H2Teesside Project

Document Reference: 9.7: Statement of Common Ground between H2 Teesside Limited and Natural England

Date: September 2024

**Statement of Common Ground between the H2 Teesside Limited and
Natural England**

Figure 12-F-3: Water Vole and Otter Survey Results

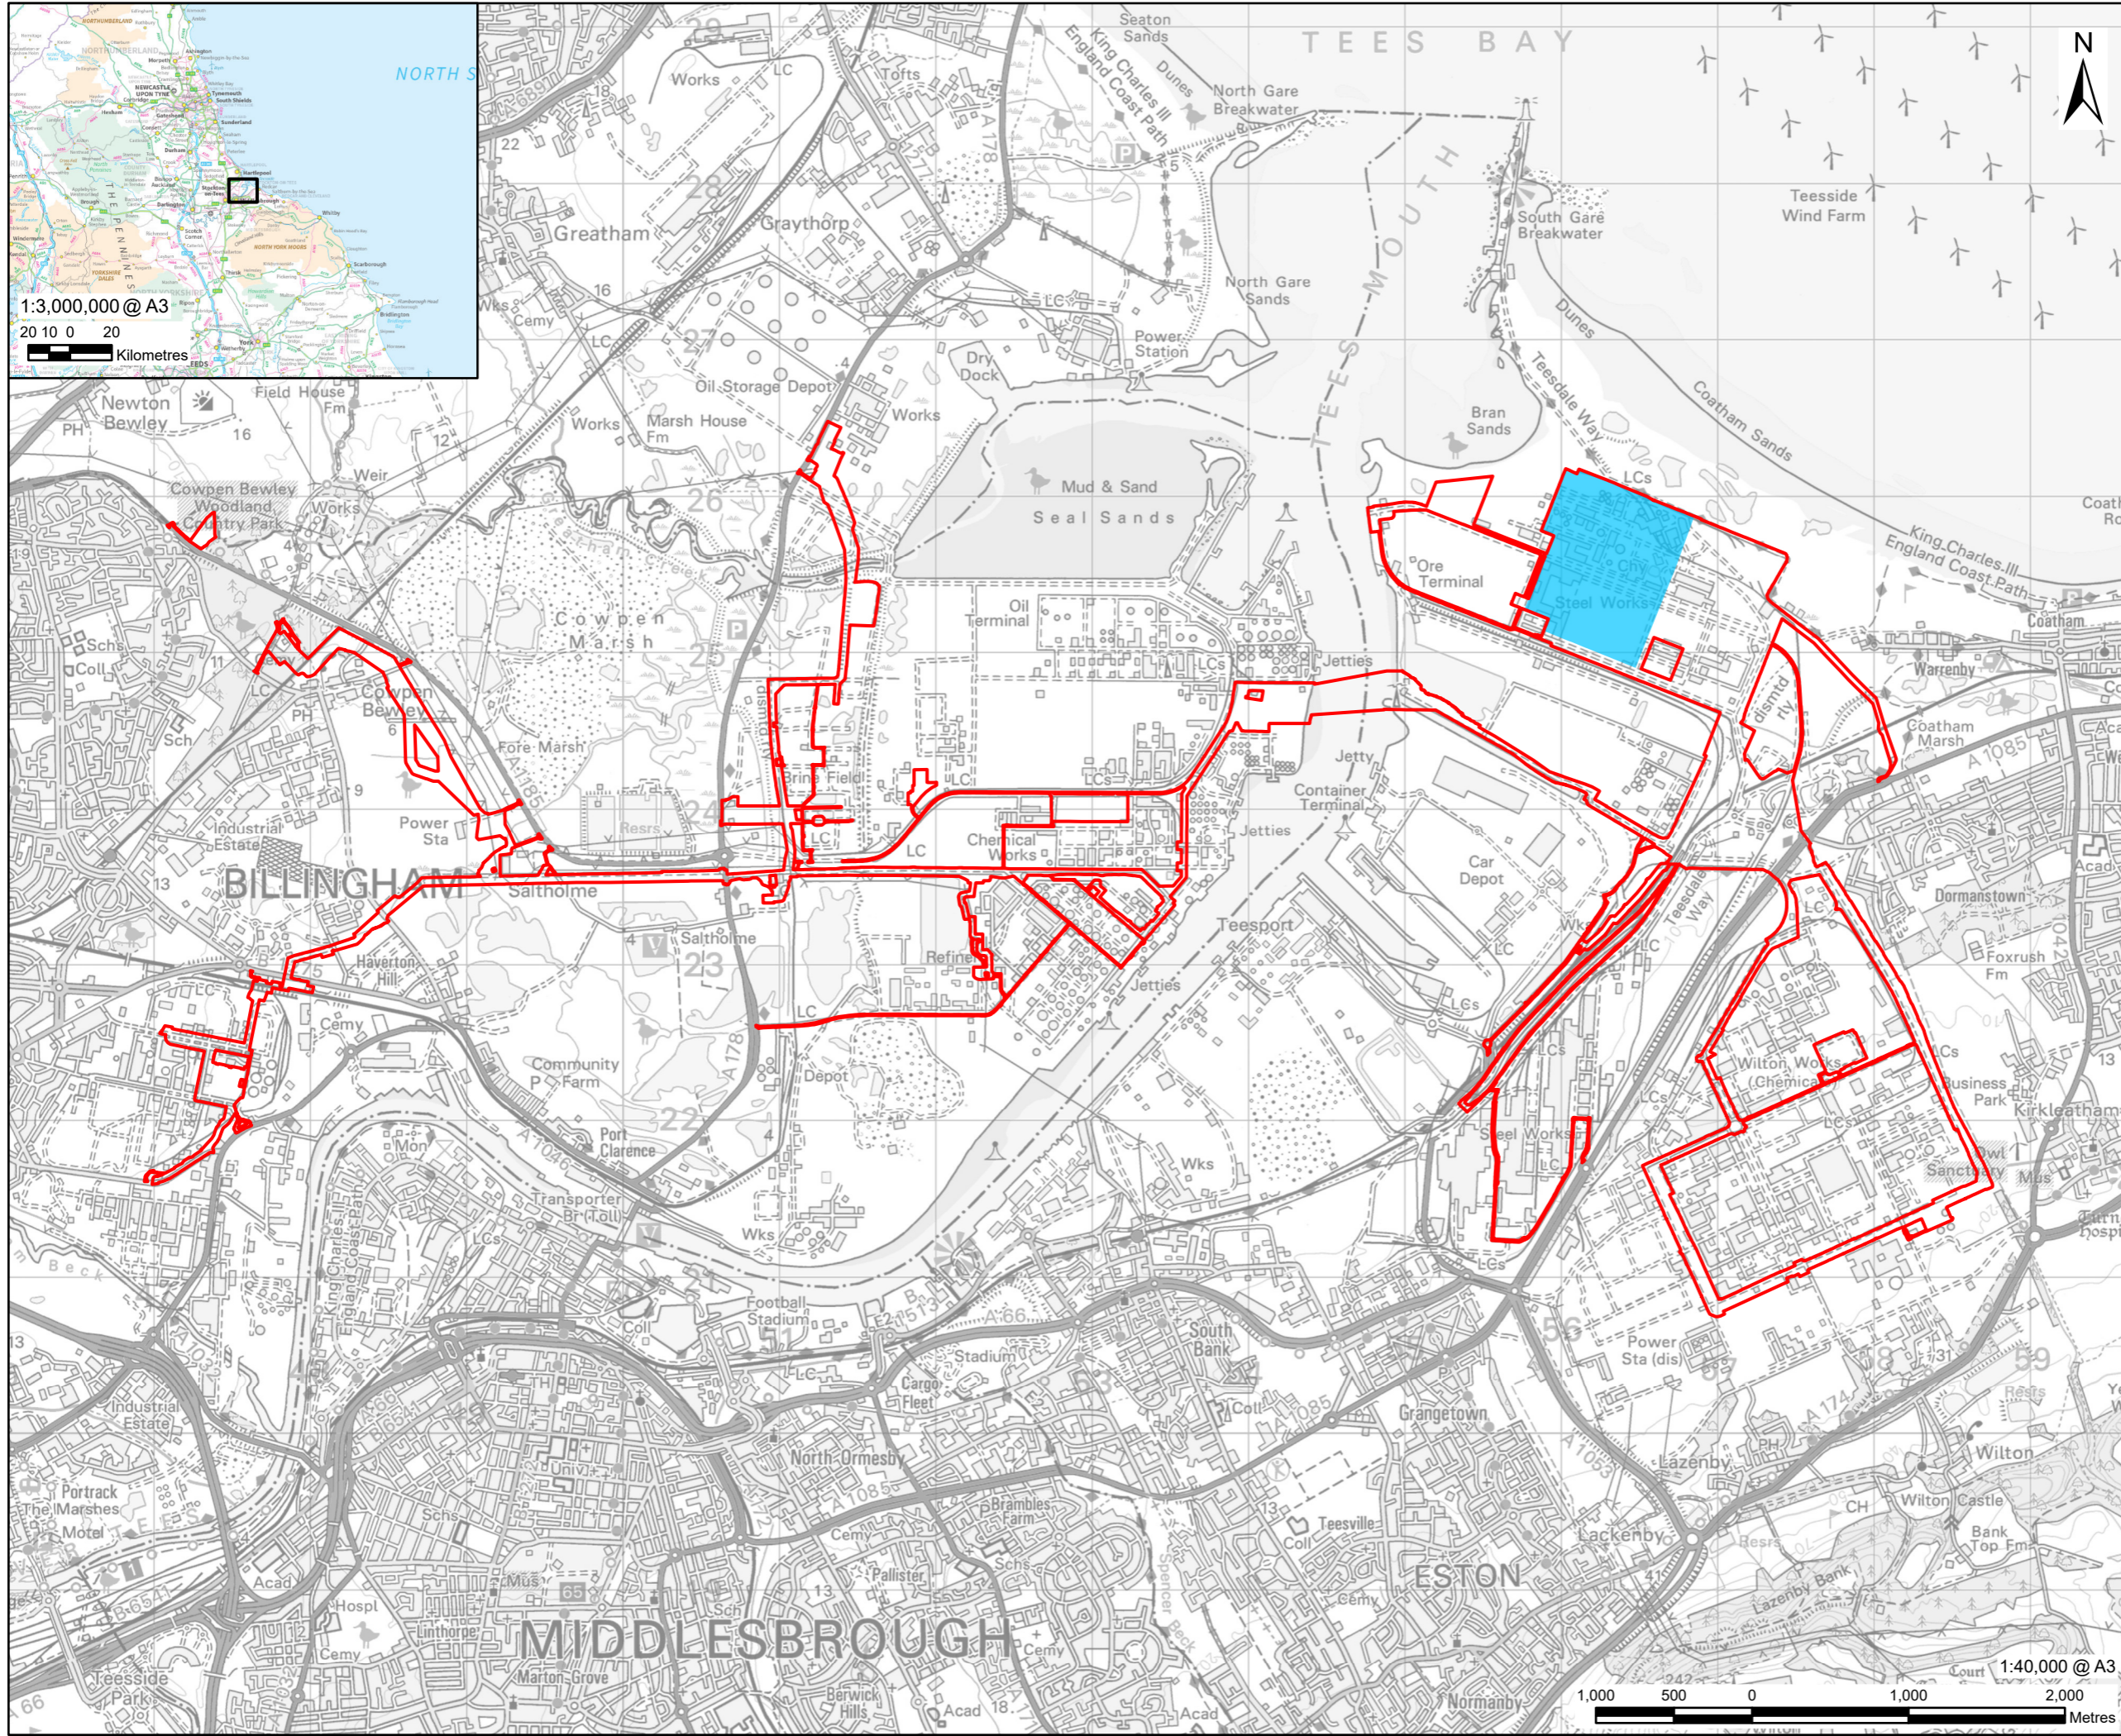
9.	Water Vole Surveys and Appendix 12F [APP-206]	A desk study and field surveys have been conducted to inform the Proposed Development. During the 2023 field surveys, limitations were encountered due to the presence of nesting birds in areas to the north of Greatham Creek, Holme Fleet, and Belasis Beck. These areas were subsequently surveyed later in the season to avoid disturbing the nesting birds.	NE advises a second water vole survey should be conducted prior to works proceeding, this is considered best practice. NE have not been able to review Appendix 12F [APP-206] due to redaction (Ref. NE33).

SOCG ID	MATTER	APPLICANT POSITION	NATURAL ENGLAND POSITION
		<p>The Proposed Development has been designed to minimise potential impacts on watercourses and water voles wherever possible. This includes implementing buffer zones to protect suitable habitats. Water bodies to the north of Greatham Creek will be avoided through the use of Horizontal Directional Drilling ('HDD'). Impacts on ditches within the Brinefields (Sabic) will be mitigated by using existing access tracks and applying buffer zones around the ditches. Belasis Beck was surveyed in 2022 for the NZT development, with evidence of water voles, such as latrines and feeding remains, being recorded. Although the 2023 survey of Belasis Beck was limited due to nesting birds, feeding remains were still recorded, indicating the presence of water voles. Similarly, feeding remains at Holme Fleet suggest the presence of water voles in this watercourse.</p> <p>As works will not commence on site until Q4 2025, updated water vole surveys are proposed to inform the final mitigation requirements, including the need for a development licence. This is secured via the Framework CEMP [APP-043]. Following these updated surveys, a water vole impact avoidance</p>

SOCG ID	MATTER	APPLICANT POSITION	NATURAL ENGLAND POSITION
		<p>strategy will be prepared if required. This document will outline all measures and supervision required to ensure legislative compliance during the construction of the Proposed Development.</p> <p>The Applicant has provided the figures contained within Appendix 12F [APP-206] to NE.</p>
